**Transport
for NSW**

**Walsh Bay Arts and Cultural Precinct (SSD 8671) – Response to Submissions
Lot 11 DP 1138931 (Pier 2/3) and Lot 65 DP 1048377
(Wharf 4/5 and Wharf 4/5 Shore Sheds), Walsh Bay**

TAB A – Suggested Conditions of Consent

WALSH BAY ARTS PRECINCT
LOADING DOCK - SWEPT PATH ASSESSMENT
6.4m SRV

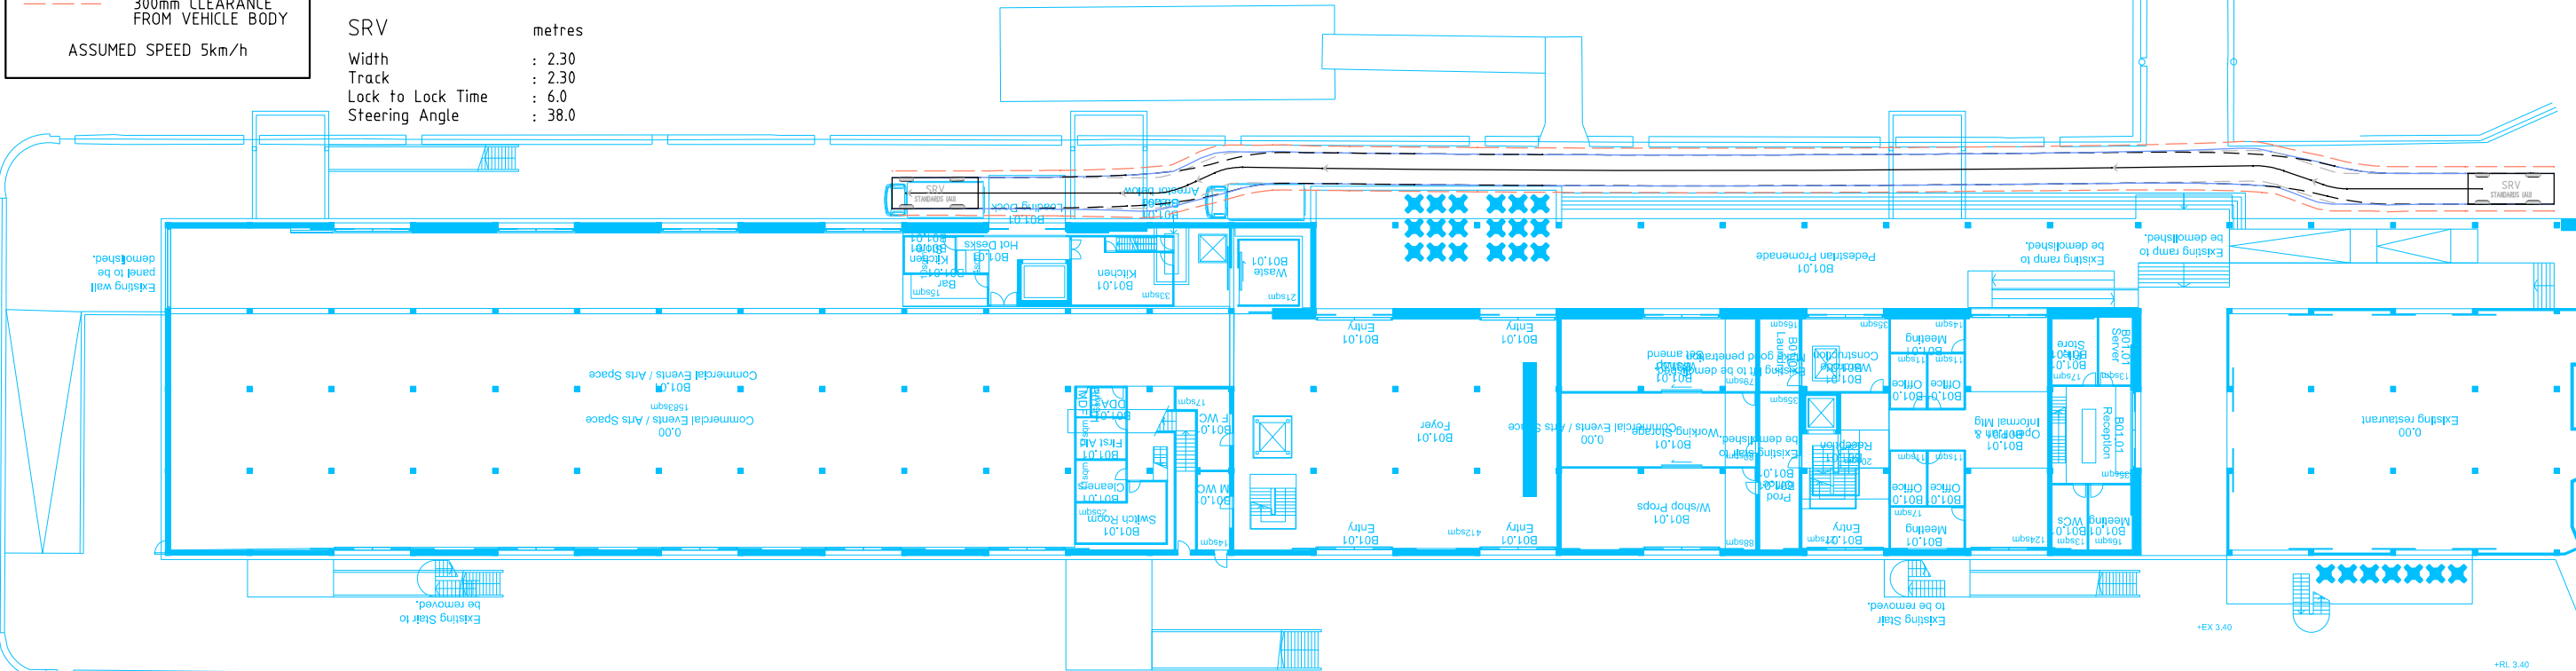
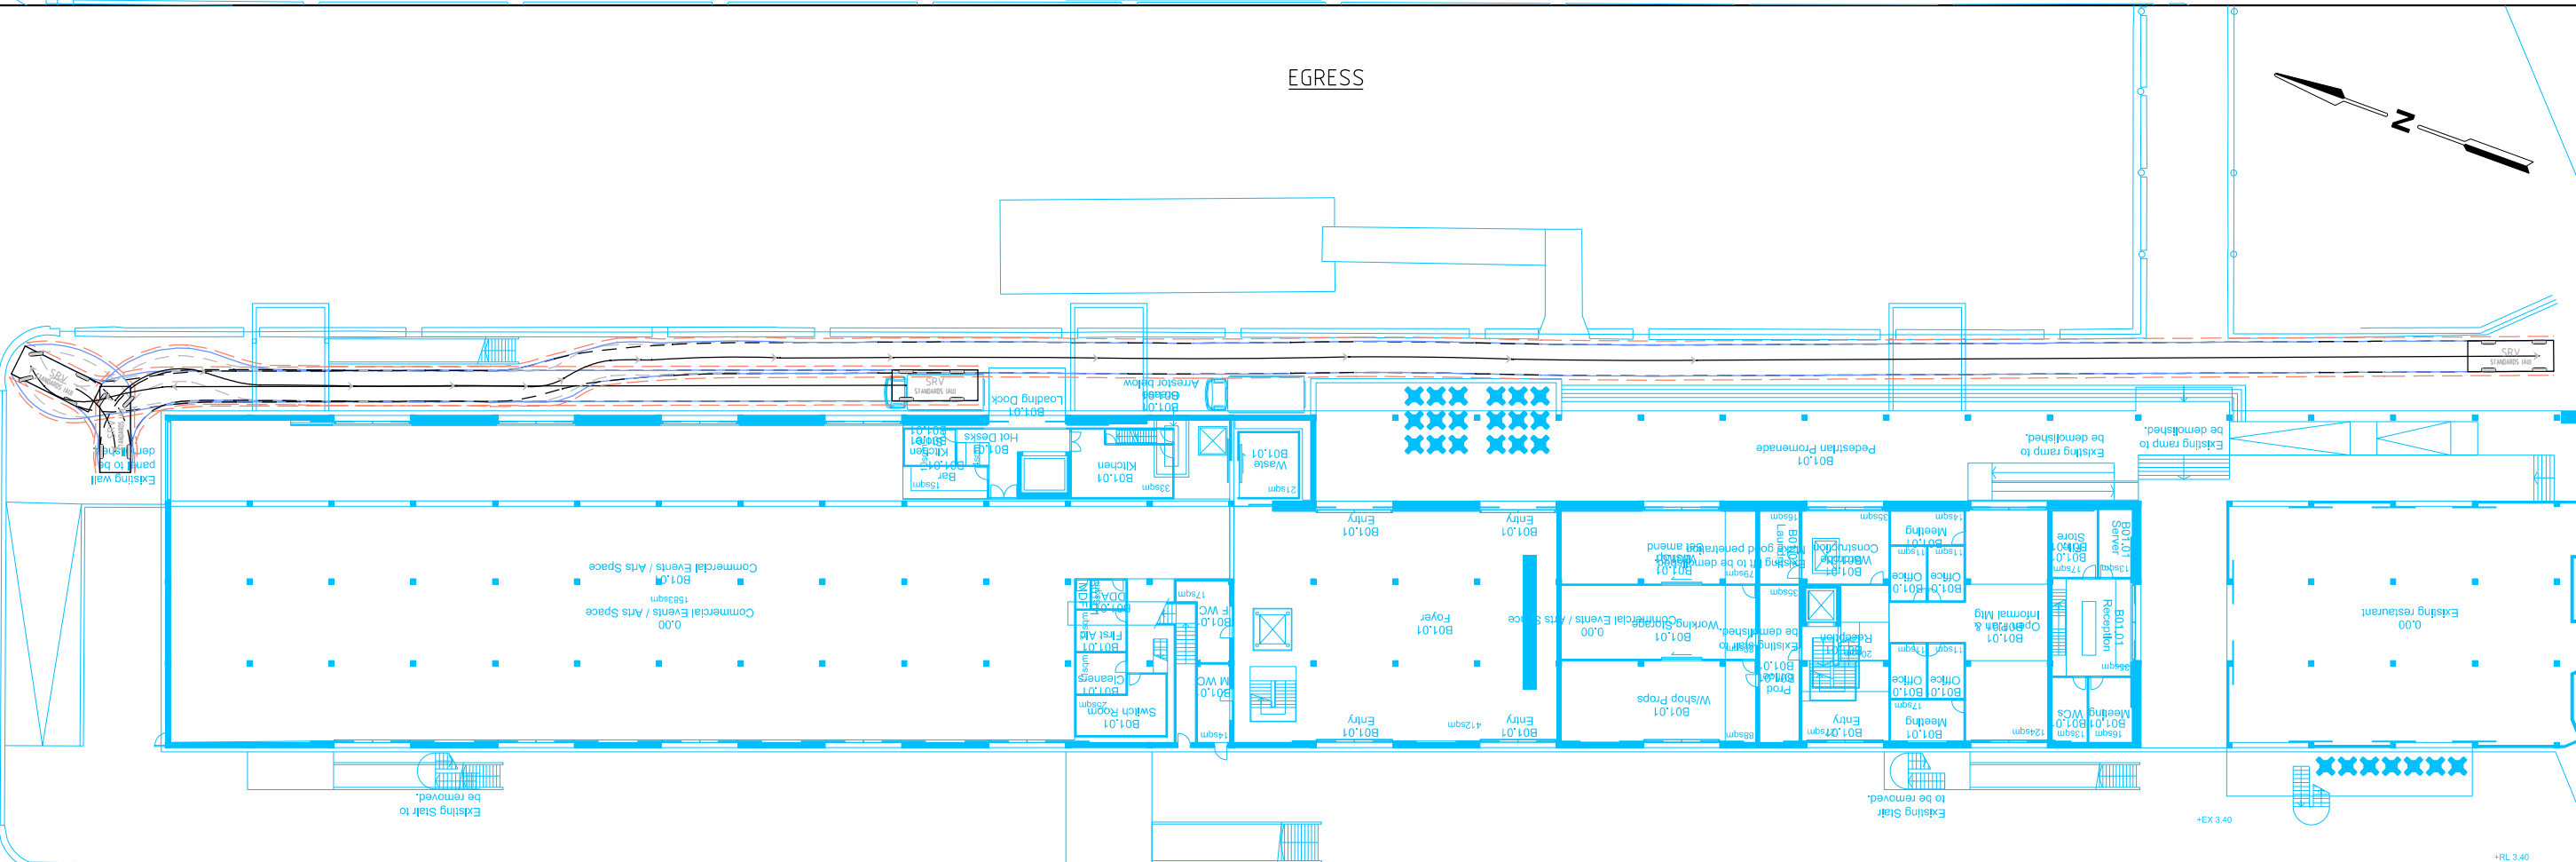
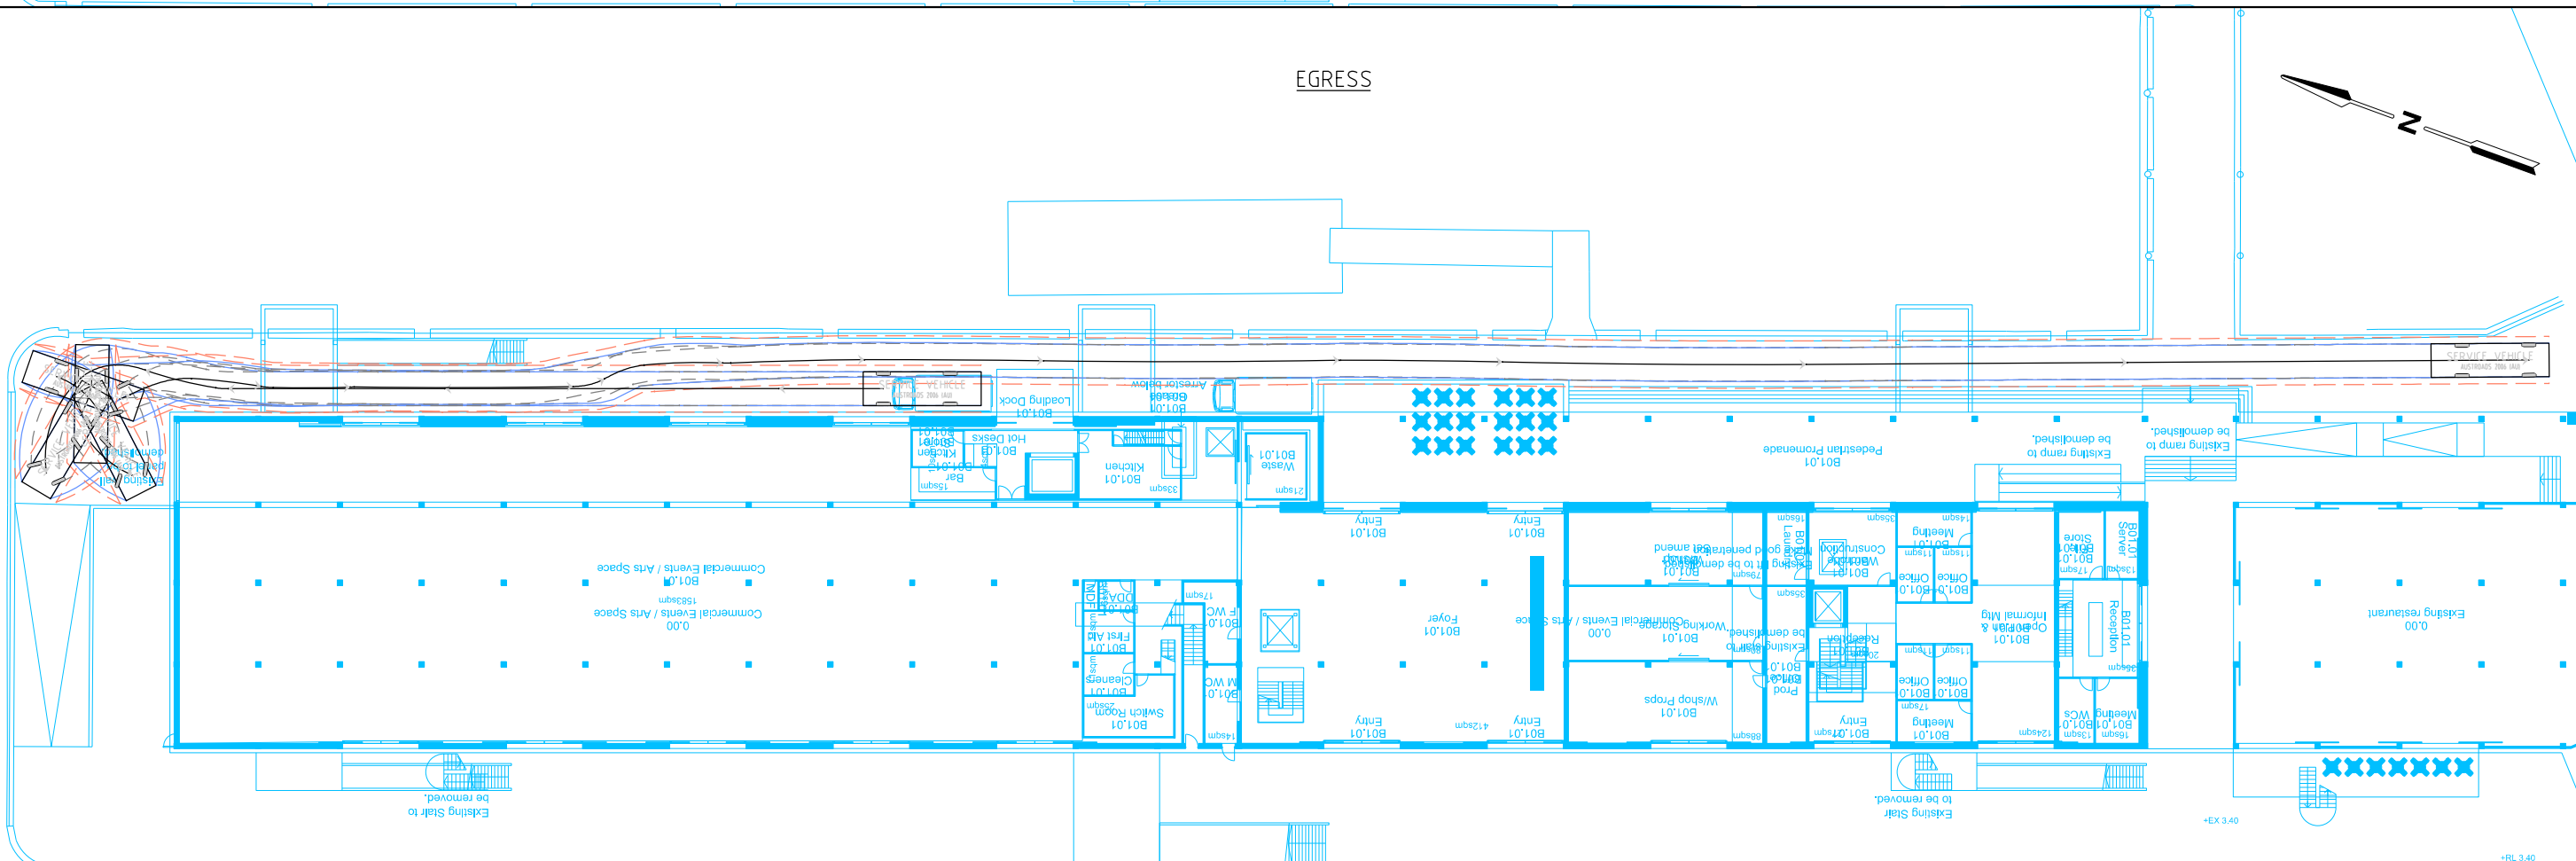
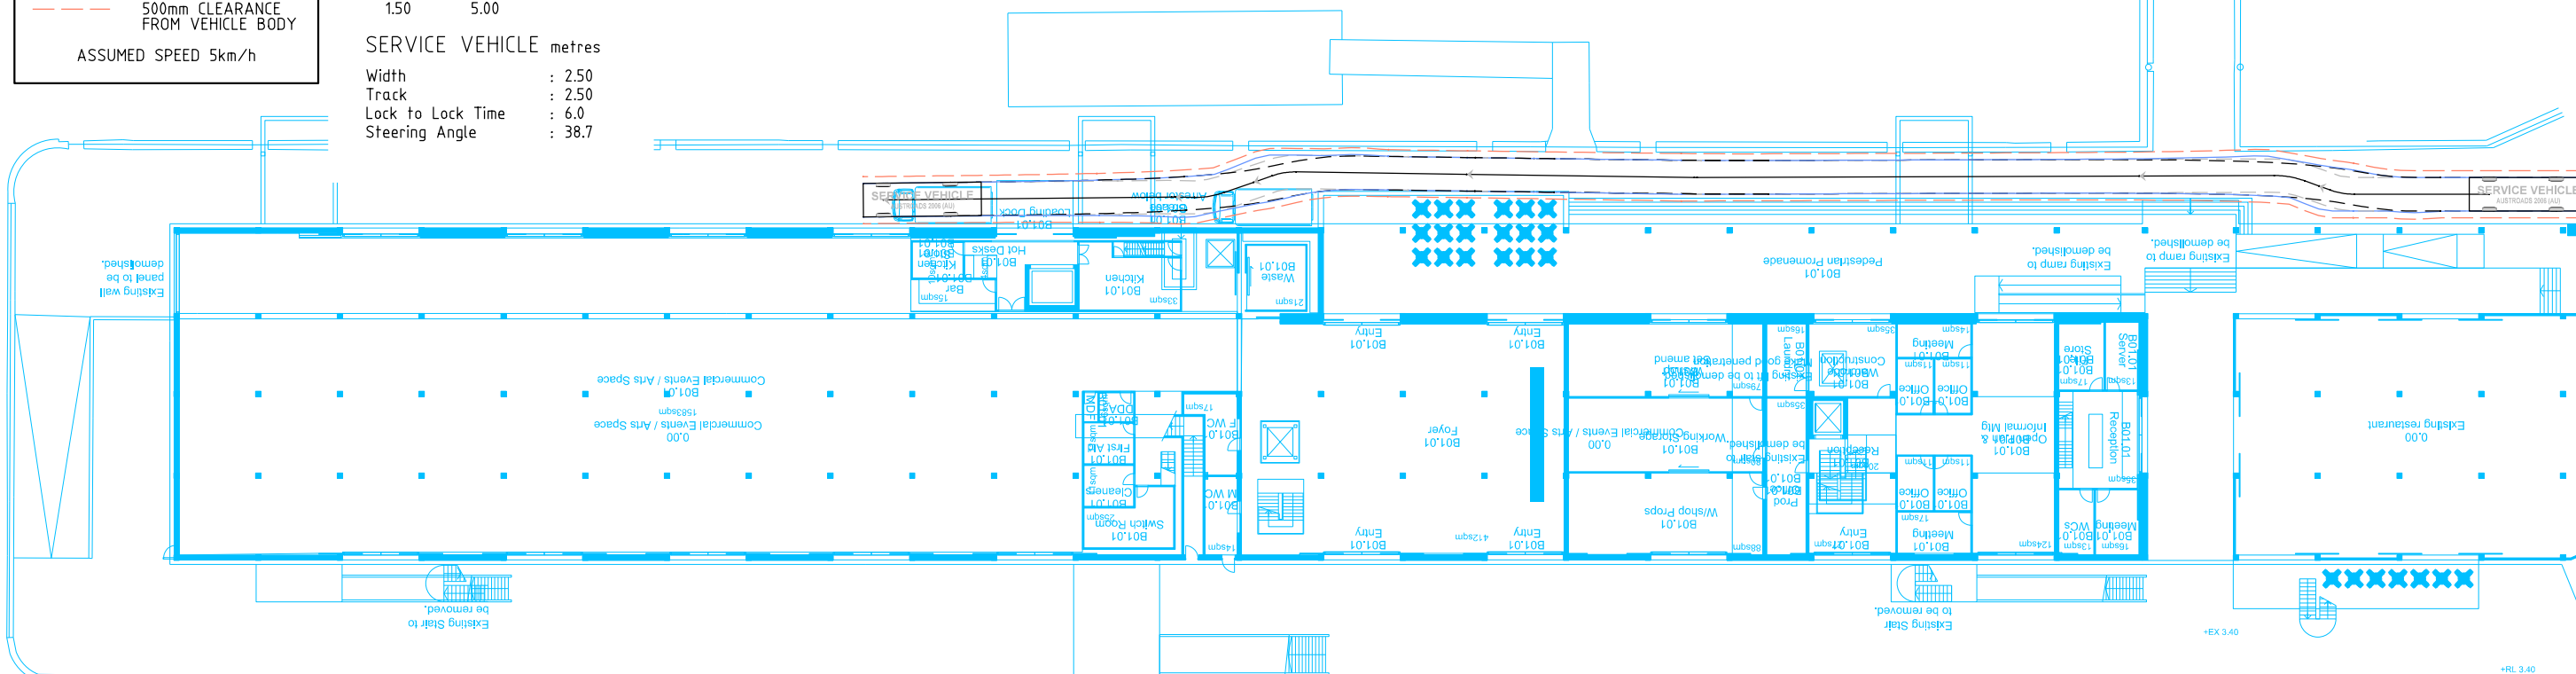
The Response to Submission states the following:

- Any passing movements would need to be undertaken with one vehicle parked hard up against the building or edge of the wharf and the other vehicle would be required to pass at low speed. This issue could be mitigated by ensuring that only one vehicle accesses the apron at any given time and during the detailed design phase, appropriate passing bay locations are identified to provide safe passing opportunities for instances when two vehicles are required to pass each other;

- Swept paths have been undertaken and are provided in the Response to Submissions. The applicant considers that no additional infrastructure works are required to the loading dock areas for the project; and
- Given the above, the applicant considers that the Logistics Management Plan should be prepared prior to occupation and not prior to construction as requested.

It is advised that:

- The proposed access arrangement to the loading dock would have the potential to impact on the operation of Hickson Road with only one vehicle accessing the apron at any given time and other vehicles waiting to be served along Hickson Road; and
- A draft Service and Loading Dock Management Plan needs to be developed prior to construction as appropriate passing bay locations may require some detailed design changes. The opportunity for detailed design changes would be lost if identified post construction.

- The applicant shall prepare a draft Service and Loading Dock Management Plan prior to the issue of any construction certificate, in consultation with the Sydney Coordination Office within TfNSW, to minimise impact on the general traffic and bus operation within the CBD. A final version of the plan shall be submitted to the Coordinator General, Transport Coordination within TfNSW for endorsement, prior to the issue of any occupation certificate.
- All loading and service vehicles associated with the use of the premises shall be accommodated within the subject site at all times.
